CASA Ref: F24/25602-1
Your Ref: SSD-50505215 Wed 21/08/2024 4:19 PM

MAJOR PROJECTS – BULLAWAH WIND FARM SSD-50505215, CASA COMMENTS

Figure 1 Proposed obstacle lighting layout

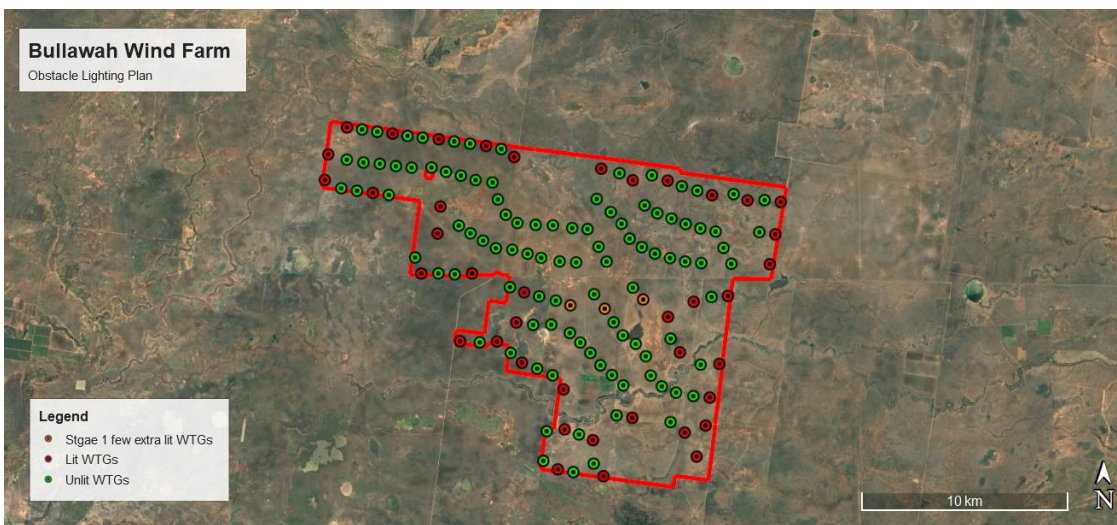
International standards require 2,000 candela lighting intensity on the nacelle / generator housing (also recommended in the NASF guideline) and 200 candelas at the mid-point of the turbine mast. CASA recommends that 200 candela as a minimum intensity lighting on the nacelle would suffice (due mainly to the lack of background lighting in the vicinity of the turbines). Mid-point lighting on

the turbine mast is not essential. The obstacle lighting should be monitored to alert the wind farm operator of any outage. The lighting system design should ensure that some of the obstacle lights remain on during an outage. CASA is prepared to review a lighting plan that indicates which turbines are proposed to be lit.
